Prevent • Promote • Protect

Fall Mountain Farm, PPR-22-46

Please accept the following comments from El Paso County Public Health for the request referenced above:

Mike McCarthy
El Paso County Public Health
719-332-5771
mikemccarthy@elpasoco.com
03October2022

OWNER NAME AND ADDRESS:
 STEVE & CATHY ROSCIO
 FALL MOUNTAIN FARM COMPANY
 16300 MT. HERMAN LANE
 MONUMENT, COLORADO 80132
 PHONE: (719) 800-1244
 EMAIL: info@FallMountainFarm.com

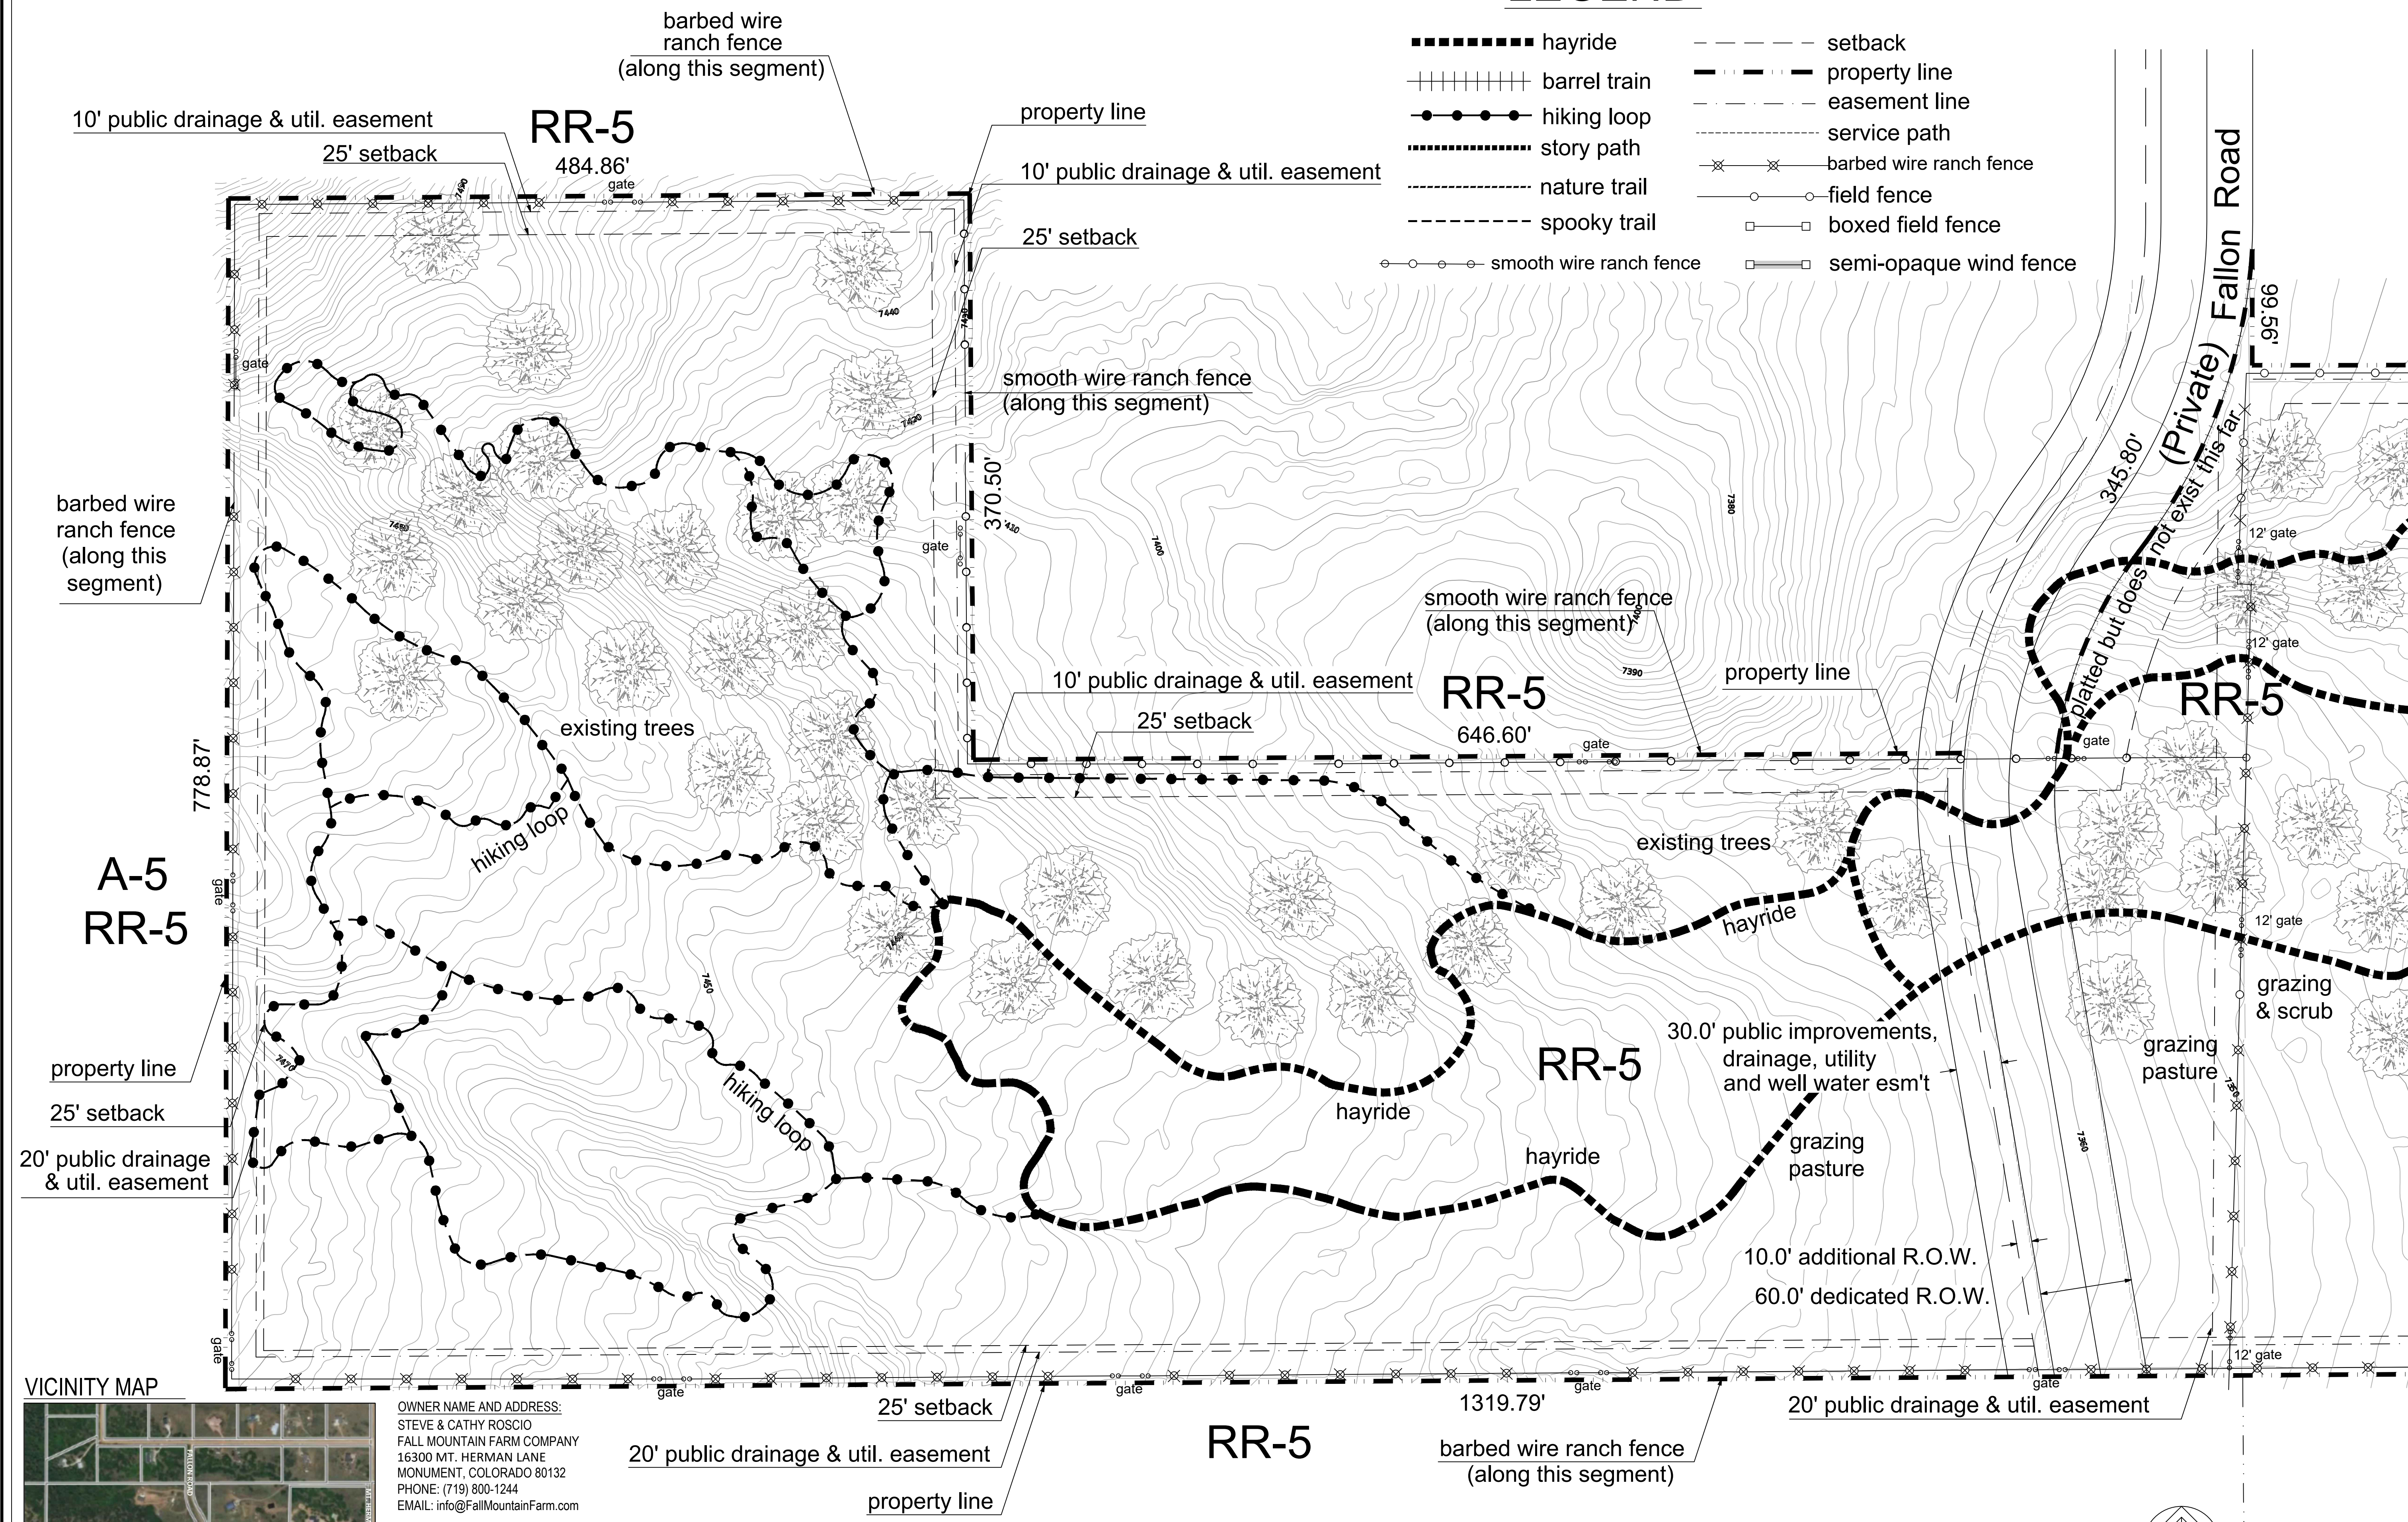
- Animal waste must be collected and removed as needed to minimize odors, and insect/rodent attraction.
- The existing residence is connected to an onsite wastewater treatment system (OWTS) installed and approved in 1987 for a 4-bedroom house. Please locate the OWTS soil treatment area to make sure traffic and parking will not be in the proximity to the soil treatment area.
